Re: Drainage Plan Certification  
Lots 4, 5, 6, and 7, Tract 2  
Brentwood Park Addition

Re: Drainage Plan Certification  
Lots 1, 2 and 3, Tract 2, Brentwood Park Addition

Regarding: Grading Plan, Lots 1 - 7, Tract 2, Lawson Heights

LOTS 1-7, TRACT 2, LAWSON HEIGHTS

CITY OF ALBUQUERQUE PUBLIC WORKS DEPARTMENT ENGINEERING DIVISION					
TITLE: LAWSON HEIGHTS LOTS 1-7 REGRADING PLAN & DETAILS					
APPROVALS	ENGINEER	DATE	APPROVALS	ENGINEER	DATE
City Engineer			Liquid Waste		
A.C.E. - Design			Traffic		
A.C.E. - Hydrology			Water		
DRAWING NO.			SHEET OF

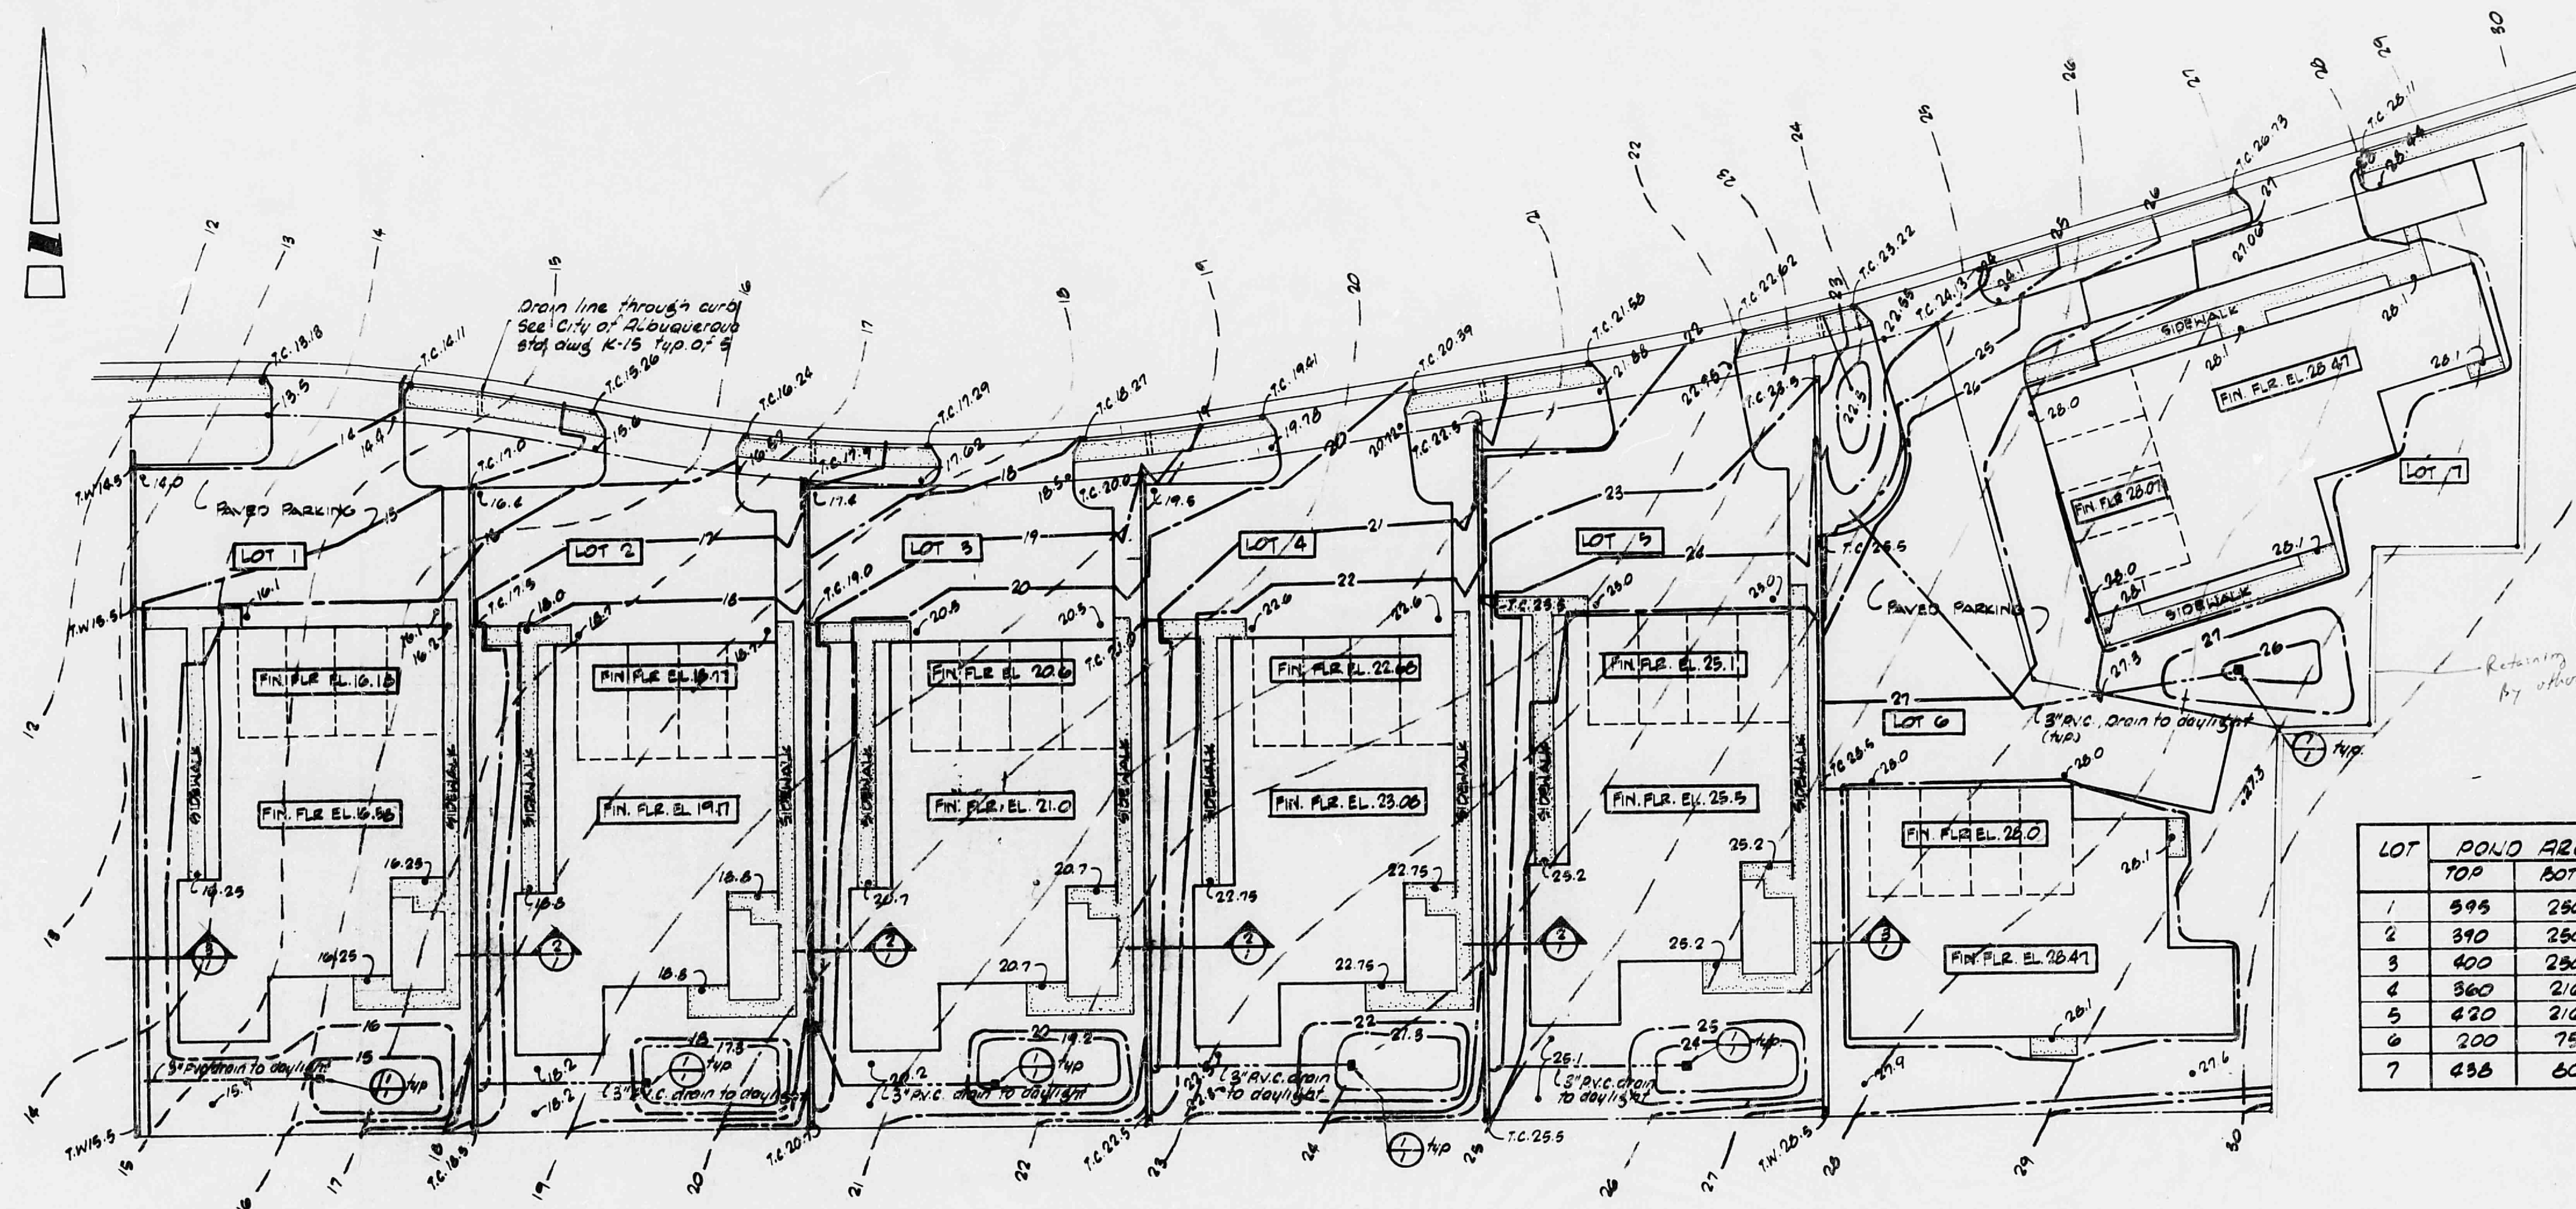
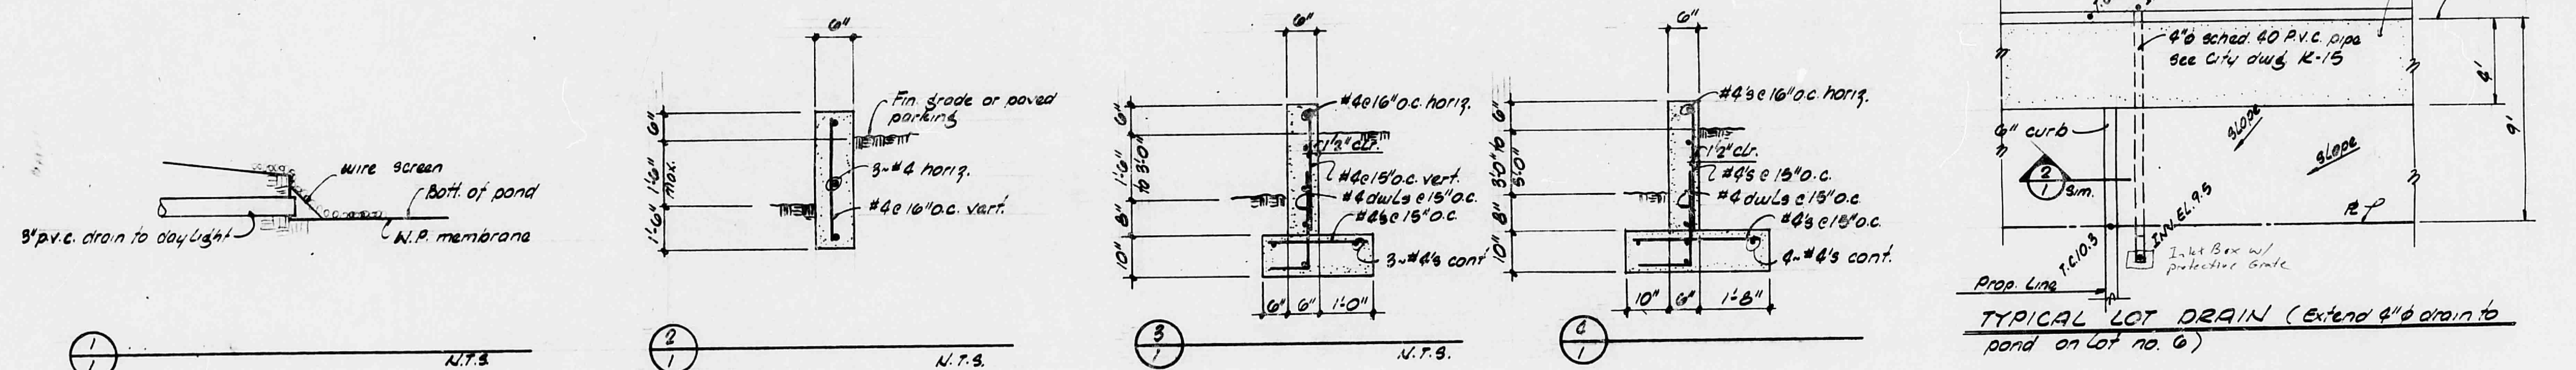
- ✓ 1) Provide pond volumes calculations for each pond; also indicate the pond limit.
- ✓ 2) Show that pond volumes balance with area contributing to the pond.

- ✓ 3) Show the pond overflow point with a spot elevation.
- ✓ 4) Provide positive discharge of ponds with required rate calculations and orifice calculations.

- ✓ 5) Show direction of roof drainage.
- ✓ 6) Outline contributing drainage areas to the ponds, including roof areas.
- ✓ 7) Comply with the required elevations for the City standard drivepad.

- ✓ 8) Provide adequate construction details of the proposed storm water discharge thru the curb.
- ✓ 9) Provide adequate construction detail to demonstrate compliance with the site's soil investigation report.

- ✓ 10) Provide a description of the temporary bench mark (T.B.M.).
- ✓ 11) Is the rear of Lot 6 intended to be a pond since no outfall is indicated with the grades?

- ✓ 12) Do you anticipate any offsite flows from the adjacent property?

1. Pond volume calculations are shown on the revised Grading Plan.
2. Roof drains have been installed to drain to the backs of the lots. Typical roof area is 2850 sq. ft. Volume contributed by the roof is approximately 594 cubic feet. Therefore the approved ponding volumes will be fully utilized.

3. See revised Grading Plan.
4. The average area draining to each pond is approximately 0.103 ac. The  $Q_5$  discharge for this area is approximately 0.32 cfs. Average discharge head with a full pond is 1.5 feet. With a 3" diameter pvc drain, peak discharge flow will be approximately 0.25 cfs. Volumes in excess of the pond capacity will escape as sheet flows to the west on lots 1-5 and across the parking area on lots 6&7.

5. All roof drains have been installed to drain to the back yards.
6. Drainage areas to the ponds basically include the roof area and back yard. Limits are shown on the attached grading plan blueprint.

7. See revised Grading Plan.
8. See revised Grading Plan.
9. Approval of the pond drain will allow the ponds to empty in approximately two hours. The landscape lining along with the drain has eliminated a need for the additional waterproofing adjacent to the foundations.

- 10.
11. No. Ponding will be provided in the front of lot 6.
12. Ponding areas east of lots 6&7 will drain through a drainage easement being provided between lots 6&7. As noted in the original approved drainage study, flows from areas south of study site will not enter the study site.
